**RE: Response to Modification of SSD 8517 – Innovation Plaza Locomotive Workshops (MOD 7)**

Thank you for inviting the Heritage Council of NSW (email 15 December 2020) to provide advice on the above Modification Request relating to the Locomotive Workshops.

28 January 2021

Drawing Title
PROPOSED ELEVATIONS

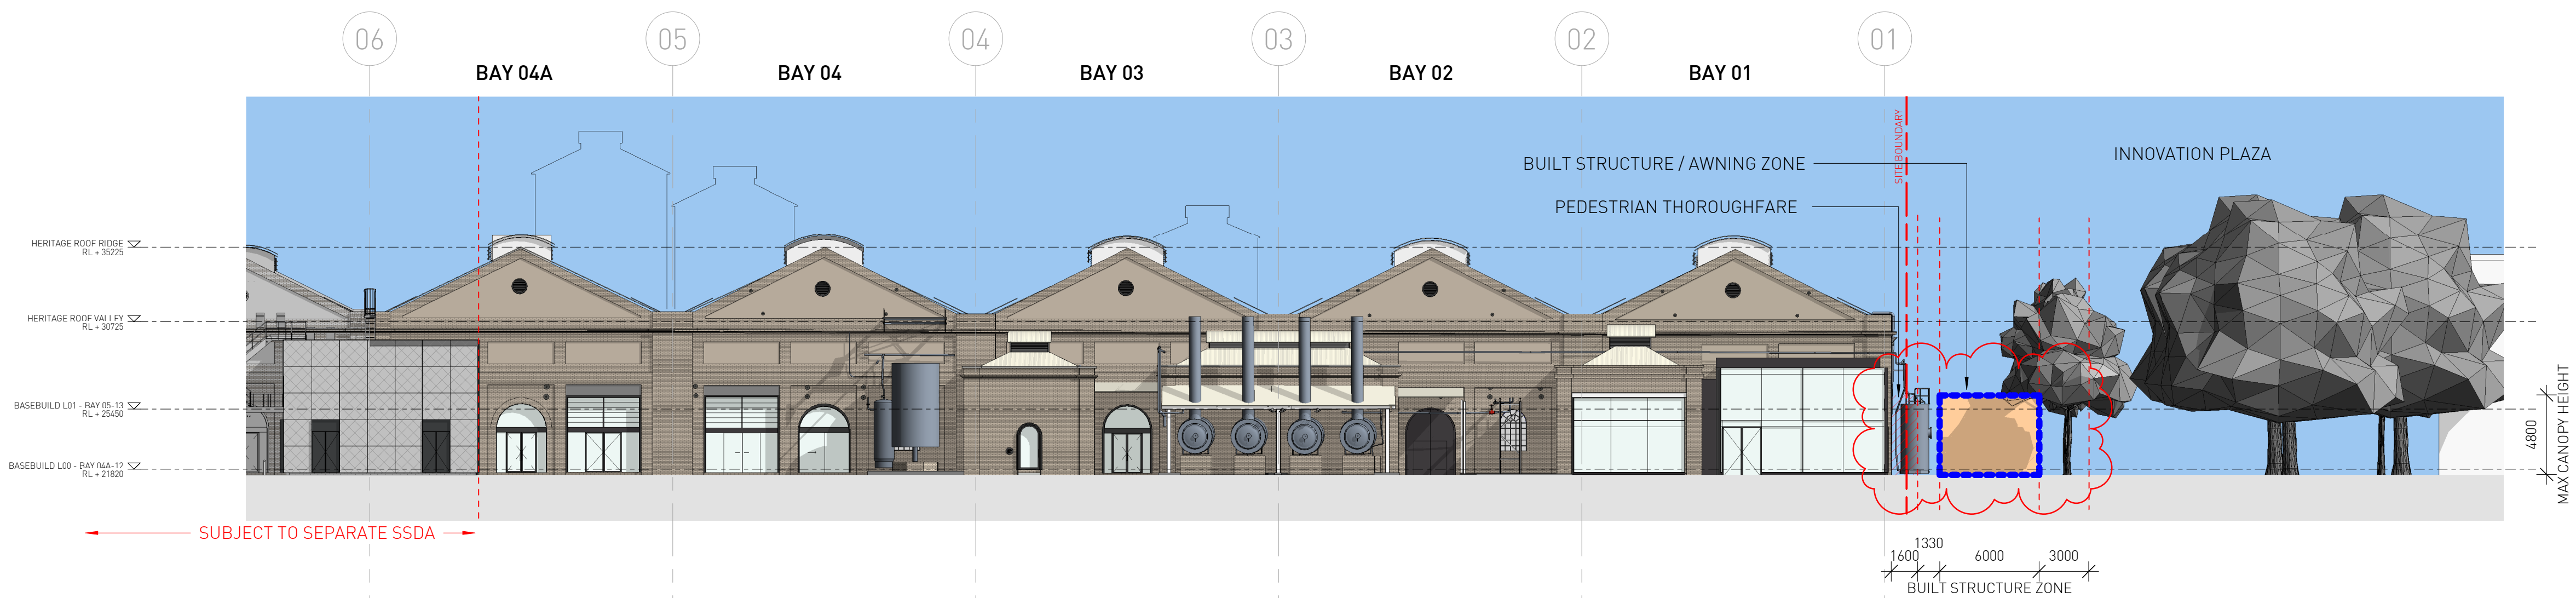
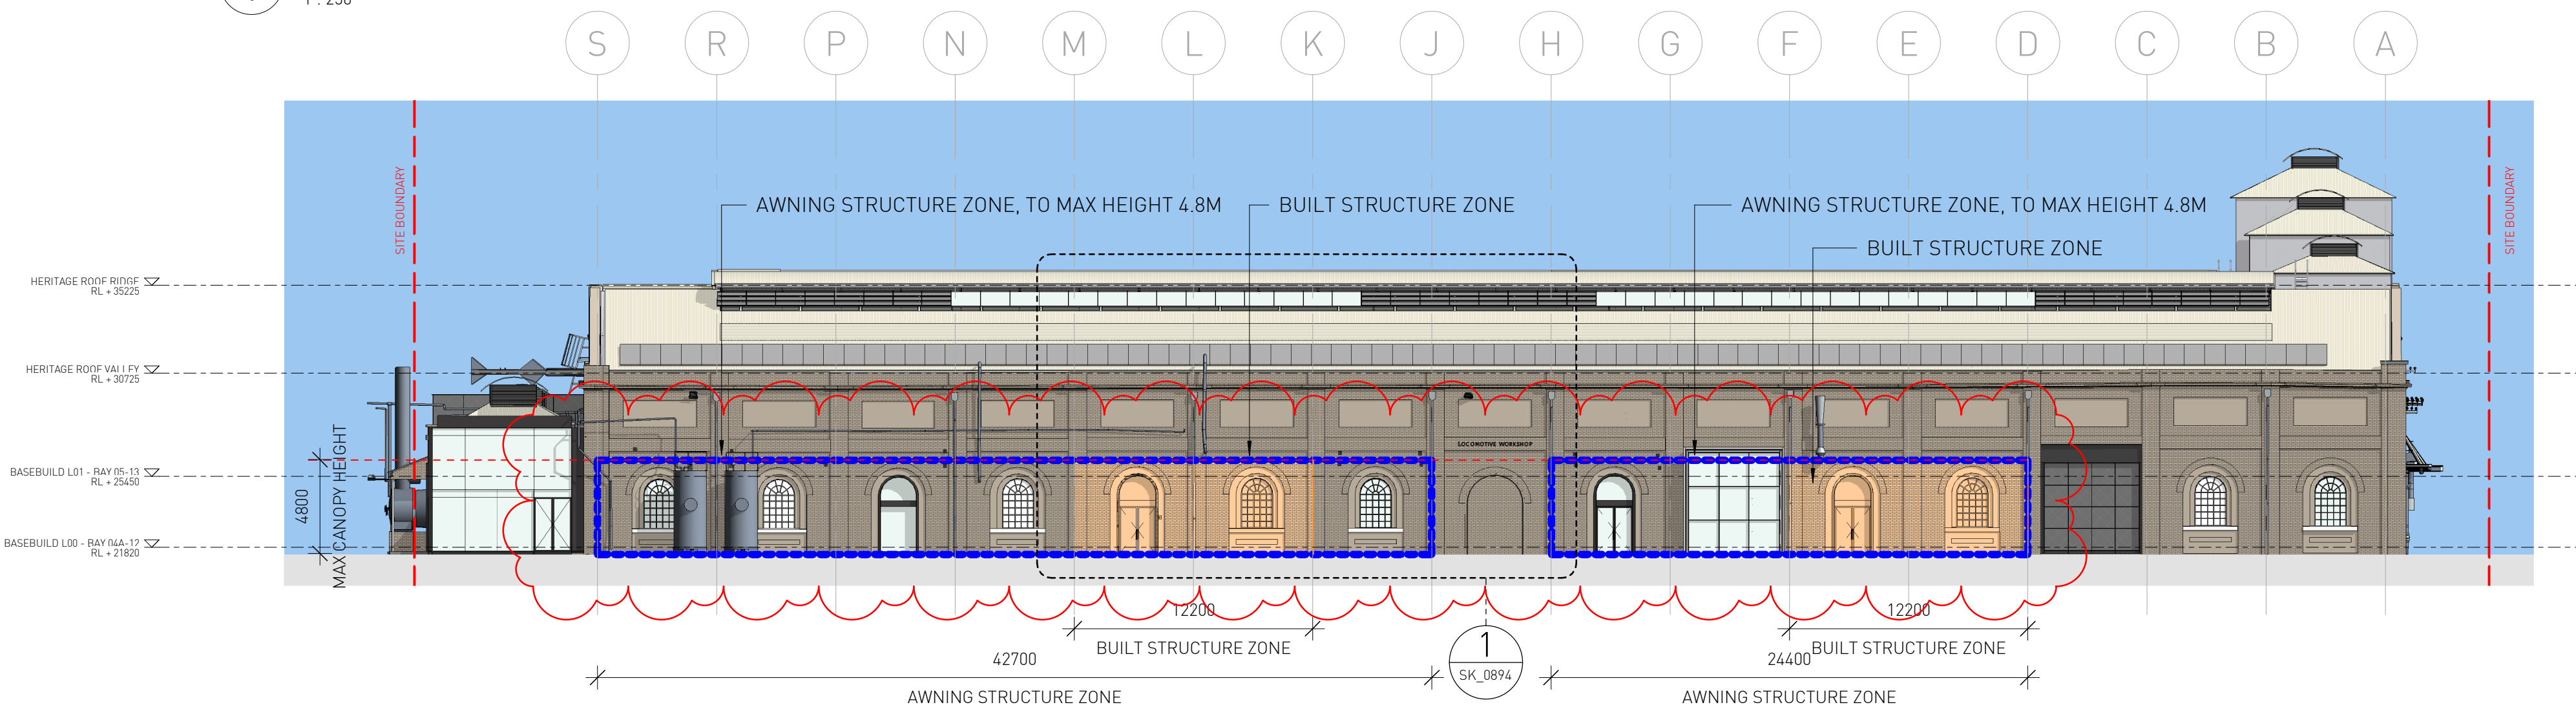
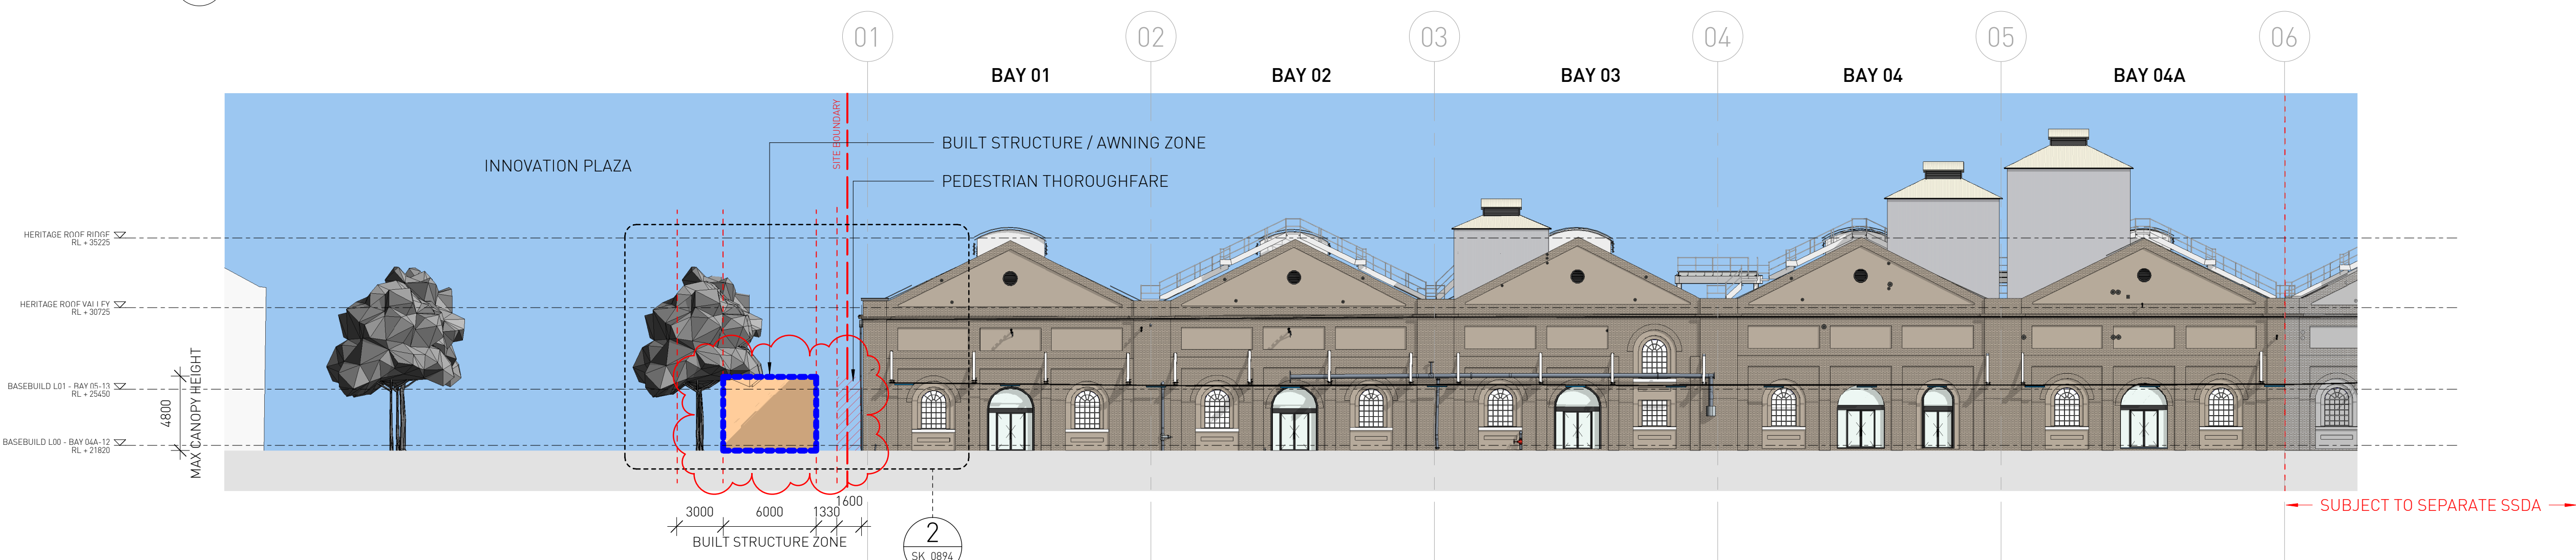
We understand that the proposed amendments are for the set out of built structure envelopes and not for the built structures themselves. However, we do not support the introduction of permanent built structures within this area. This is based on Innovation Plaza being the last uncompromised non-built space within the South Eveleigh precinct; the retention of these spatial qualities will help interpret the original form and solid-and-void composition of this important public space. This is consistent with our comments on other proposals for Innovation Plaza. We recommend that structures and built elements

within Innovation Plaza not be permanent so as to be responsive to a changing environment, to adjacent uses (existing and future) and to future strategies to activate the area. As such, we recommend that such structures and built elements be reversible (without damaging significant fabric and qualities); their reversibility and flexibility will help to mitigate potential heritage impacts.
